Our Reference: SYD14/01375/03 (A17843146)  
Council Ref: SSD6799 MOD 1

**SECTION 96(2) MODIFICATION APPLICATION- COLD STORAGE FACILITY  
LOT 10201 HOLLINSWORTH ROAD MARSDEN PARK, BLACKTOWN**

PROPOSED SITE PLAN

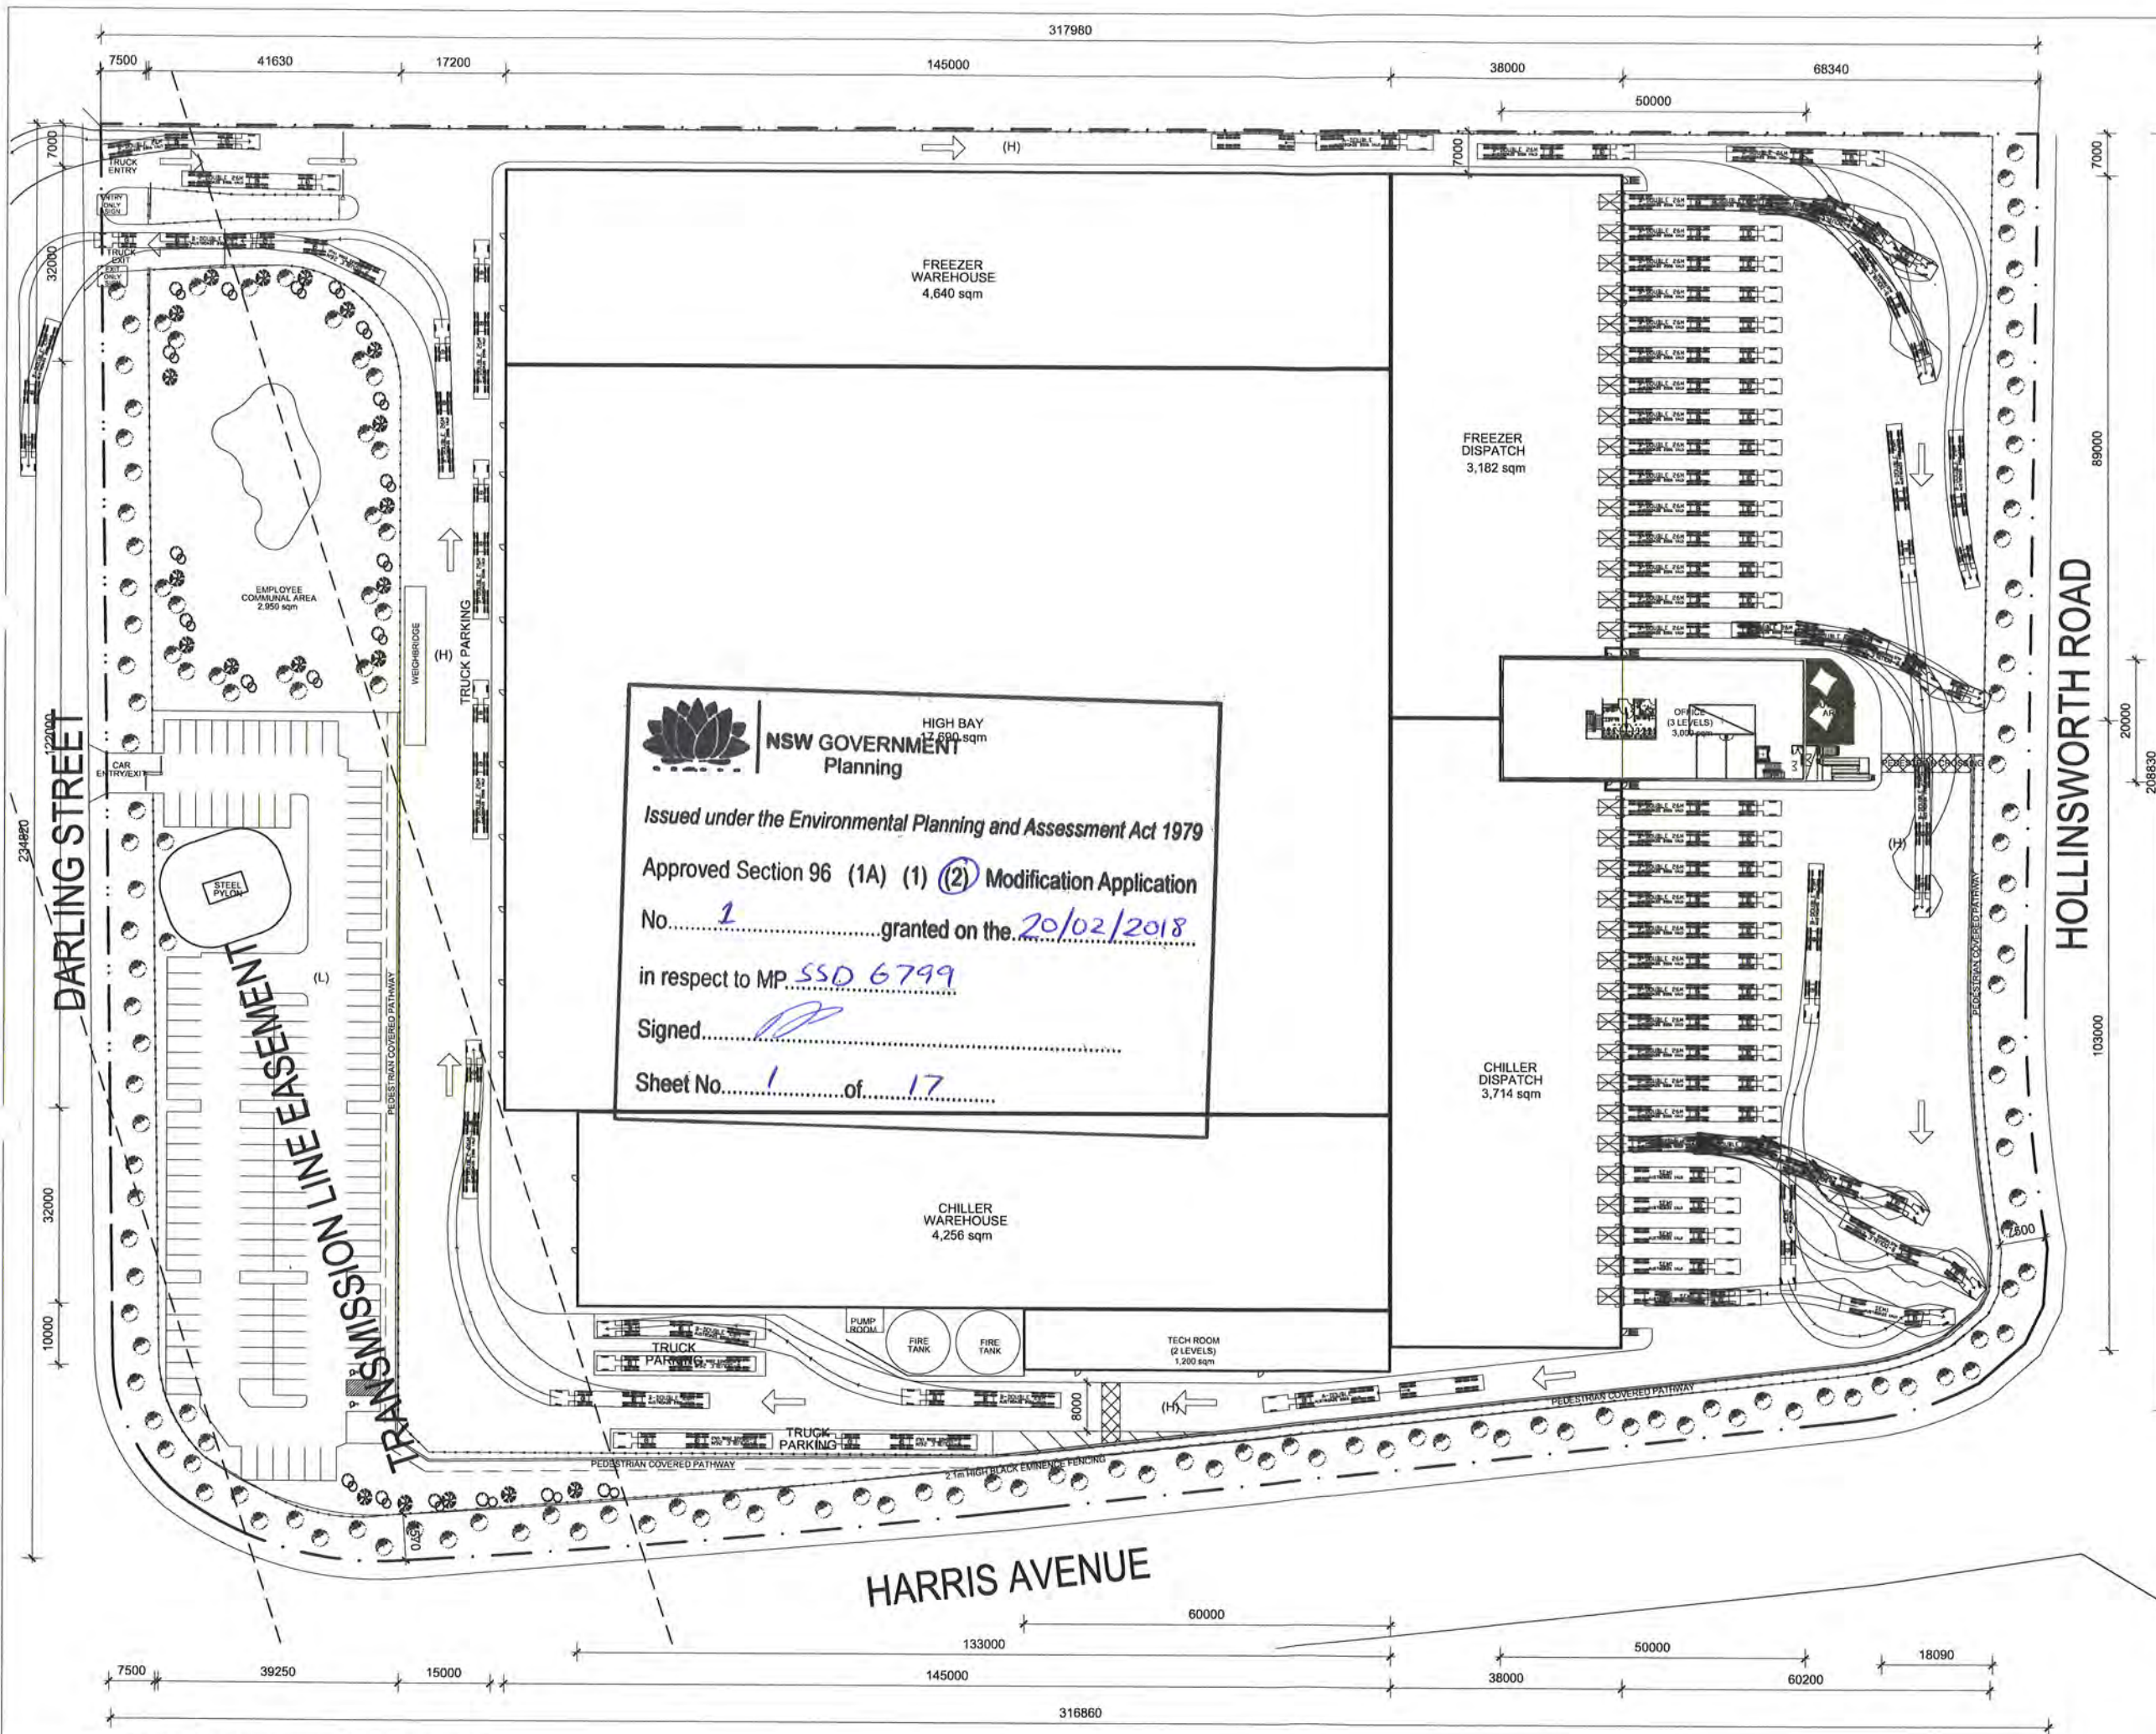
1. Updated plans depicting a single vehicle entrance and exit for the truck access way. Roads and Maritime would not support two trucks entering or exiting the driveway simultaneously.
2. Updated swept plans displaying the turn parts for both the entrance and exit to the site.
